**From:** Nicola Spencer on behalf of Planning.Responses  
**Sent:** 12 December 2025 16:26  
**To:** Planning Scanning  
**Subject:** FW: R/215/25/HH

Scales: **1:100** No: **3434/01/02**

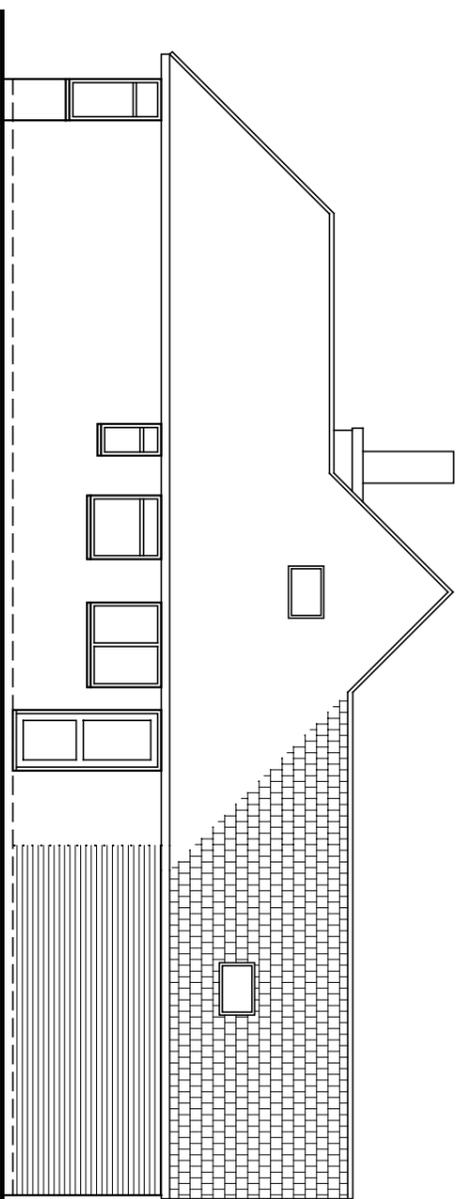
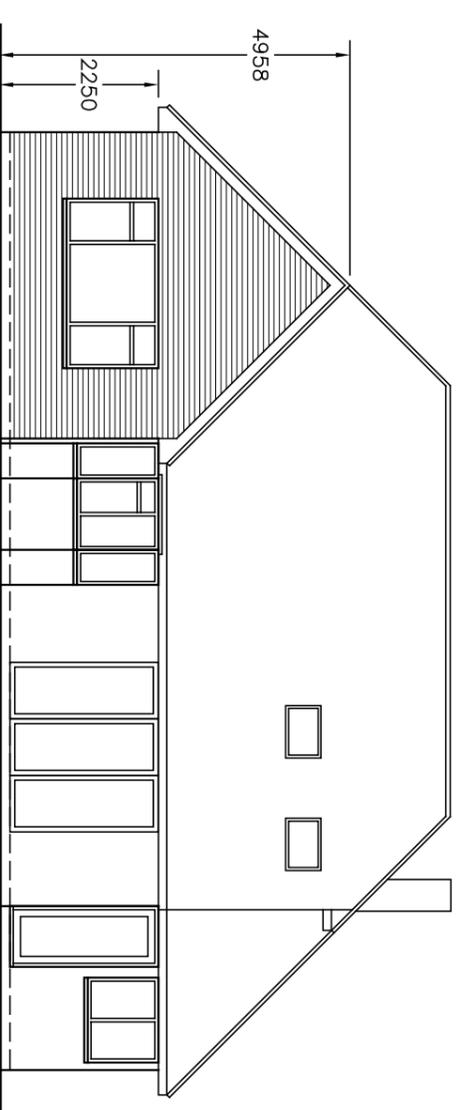
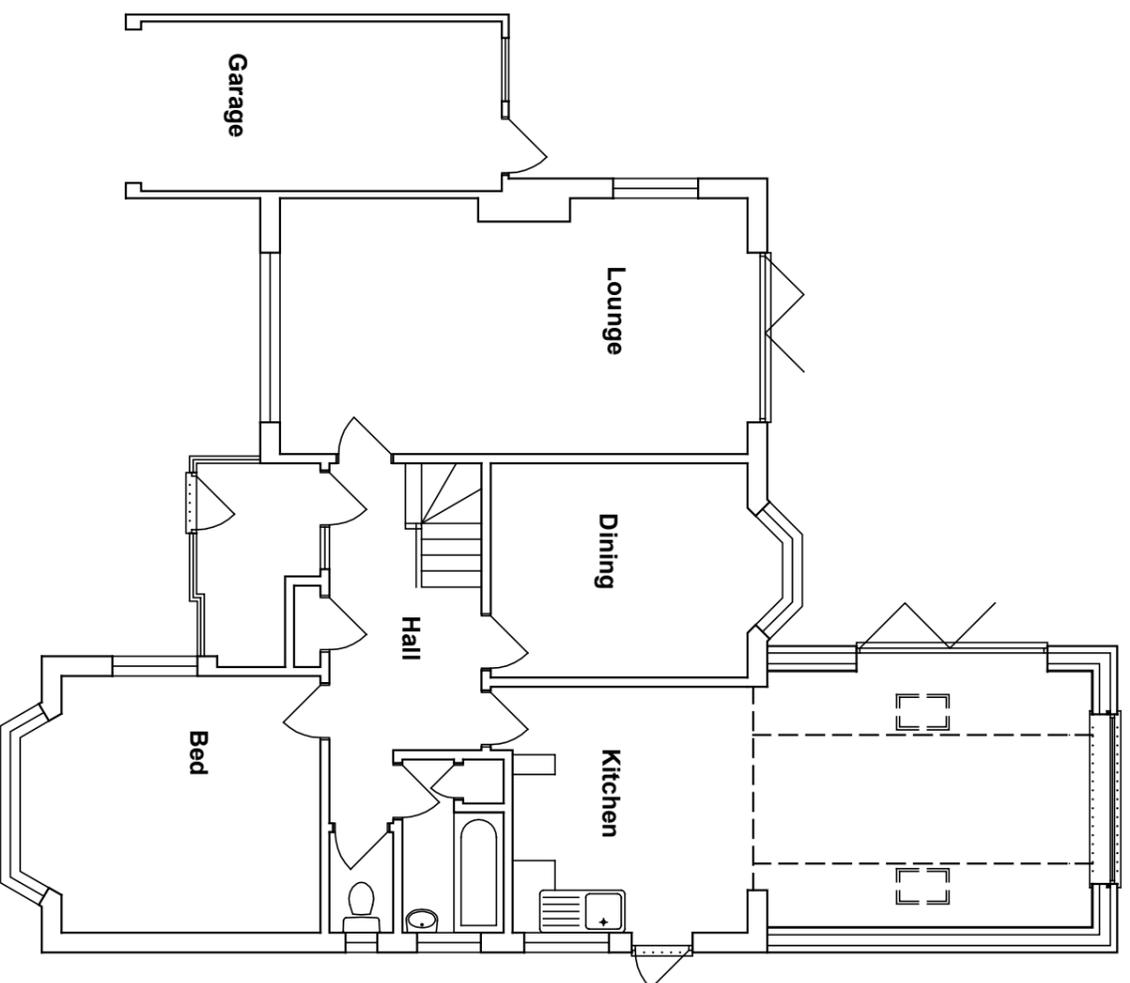
21 ft of wall on south facing border i fear will

- Overlooking and overshadowing
- Daylight and sunlight to habitable rooms

planned extension will block sunlight to main living are and also conservatory,

my south border where light comes from is where thompsons plan to build ,wall and gutter will be high enough to make this occur
